NORTH FALLS OFFSHORE WIND FARM DEVELOPMENT CONSENT ORDER

PINS REFERENCE EN010119

**DEADLINE 8: PORT OF LONDON
AUTHORITY'S CLOSING STATEMENT**

Deep Water Route Cable Installation Areas (Future Dredging Depths) Plan

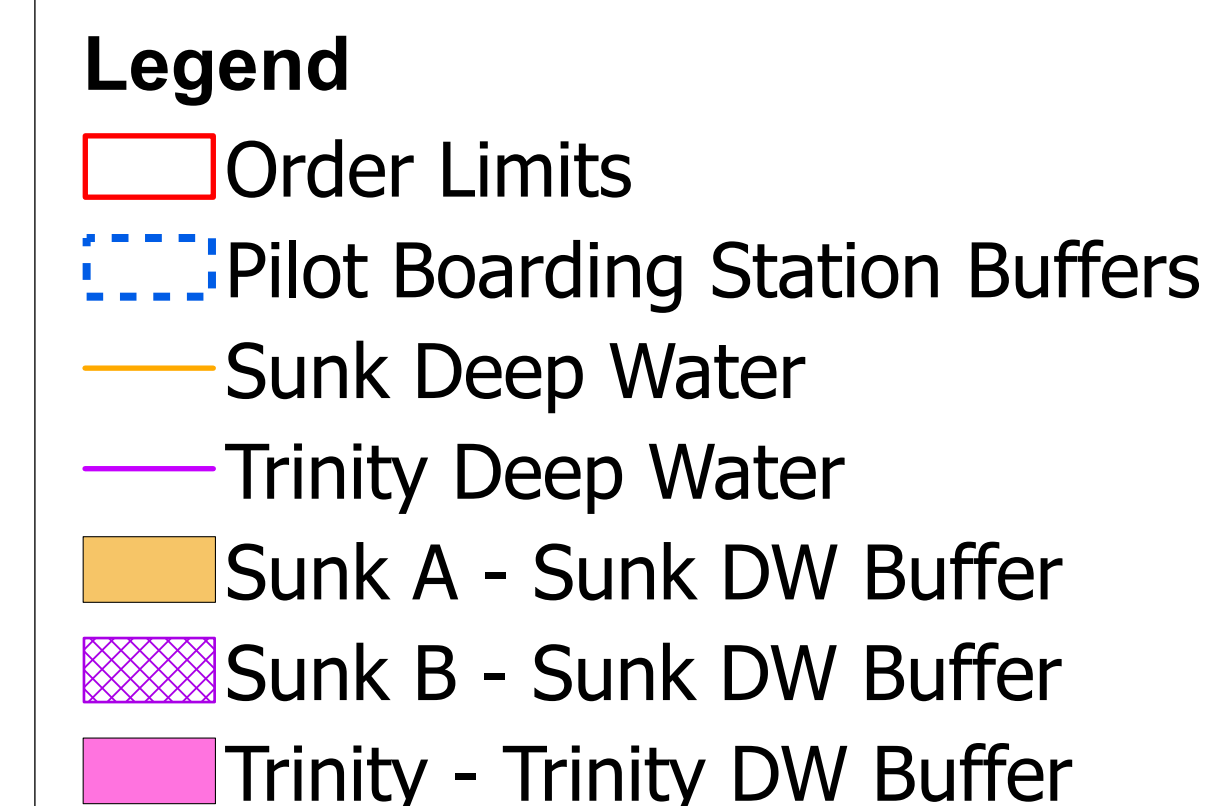
2. Safeguarding of depths at the Sunk pilot boarding and landing station	<p>The offshore cable corridor includes the Sunk Pilot Diamond this is an area rather than a specific point utilised for the boarding and landing of pilots</p> <p>The depth of the cable at the Sunk Pilot Diamond is critical and must allow vessels with a draught of 20m (plus 10% under keel clearance) to pass through the area so that pilots can board and land</p>	<p>Offshore Design Parameter – Requirement 2(3) included in the dDCO (REP7-008) agreed</p> <p>Deep Water Route Cable Installation Areas (Future Dredging Depths) Plan agreed (REP6-055)</p>

Theme	Summary of the PLA's Representations	How Resolved / What is outstanding
		<p>proposed by the ExA and gives the PLA no guarantee that the clear requirement not to undertake wet storage in the areas shown on Deep Water Route Cable Installation Area (Future Dredging Depths) Plan will in fact be secured, monitored and enforced by the MMO</p> <p>ExA Schedule of proposed changes requirement 2(4) and Schedule 9 Part 2 Condition 10(5)</p>
<ul style="list-style-type: none"> - Field joints - Freespan clearance - Dredging 	<p>Planned field joints should not be located in the DWR's or the Sunk Pilotage Area</p> <p>Applicant has not provided a clear commitment. Applicant states in response to deadline 6 submissions (REP7-053): "it is not anticipated" there will be any freespans to clear over the DWRs. Furthermore, the burial depths proposed in Requirement 2(3) should be sufficient, and any further works required due to installation issues will be captured as part of the remediation works</p> <p>Dredging undertaken for the construction or maintenance of the proposed development cannot lead to a reduction in navigable depth at the DWR's or pilot station as a result of dredged material being placed directly into these areas or migrating into these areas from disposal sites</p> <p>The PLA is content that the various scenarios have been appropriately modelled and assessed within the Hydrodynamic and Dispersion Modelling Report [REP6-054]. With Requirement 2(3) and the ExA Schedule of Proposed Changes (Schedule 9, condition 10), the size of the safeguarded areas provides sufficient protection to deal with any modelling/assessment uncertainty.</p>	<p>Para 39 of oCSIP (REP7-040) addresses this matter.</p> <p>The PLA is content that Requirement 2(3) would address this matter</p> <p>Offshore Design Parameter – Requirement 2(3) included in the dDCO agreed</p> <p>Deep Water Route Cable Installation Areas (Future Dredging Depths) Plan (REP6-055) agreed</p> <p>Addressed in oSDMP (subject to minor amendments (see entry 7 below)</p> <p>Hydrodynamic and Dispersion Modelling Report (REP6-054)</p>

Figure 2-1 – Onshore Works Plans [AS-019] overlaid with communications link LoS

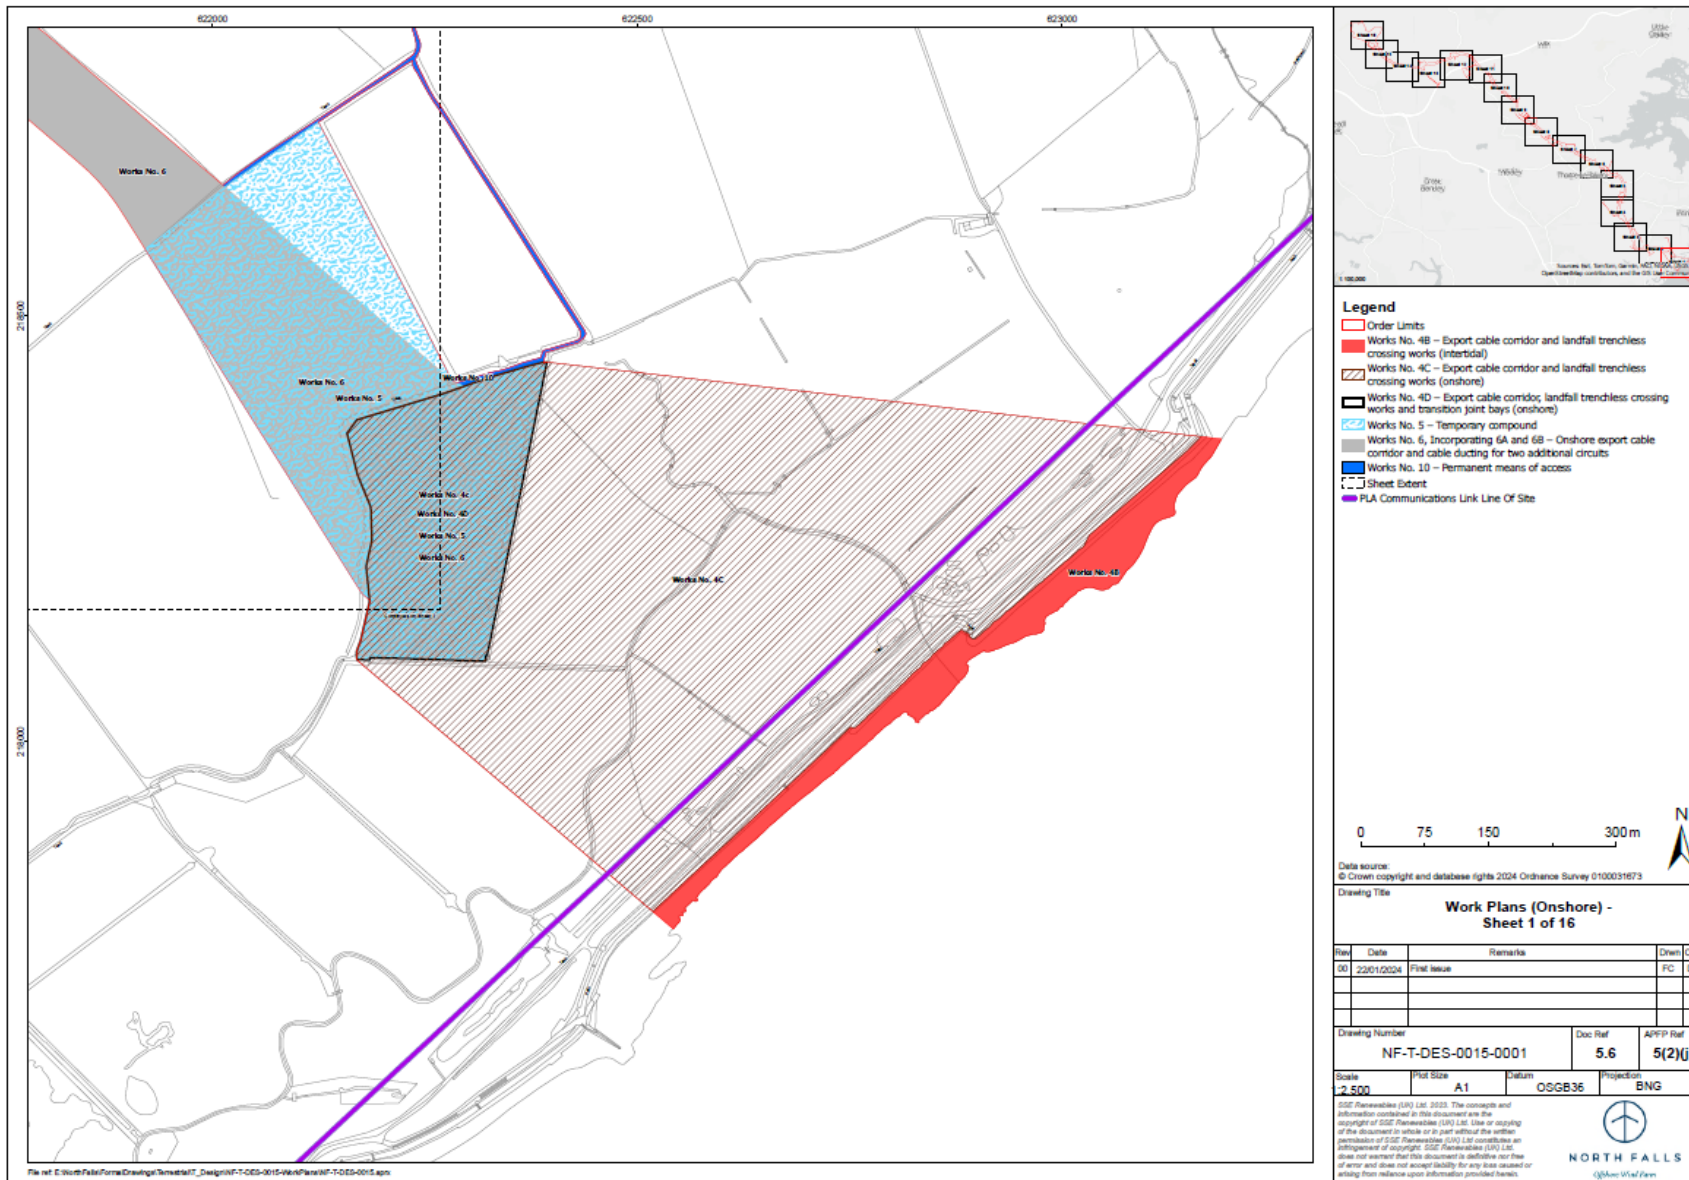
8. PLA's onshore navigation equipment	Vessels required to undertake horizontal directional drilling at landfall must not interfere with the PLA's radio link and lower its reliability	Technical Note on the Interaction of North Falls with the PLA onshore communication links REP6-067 PLA response REP7-094
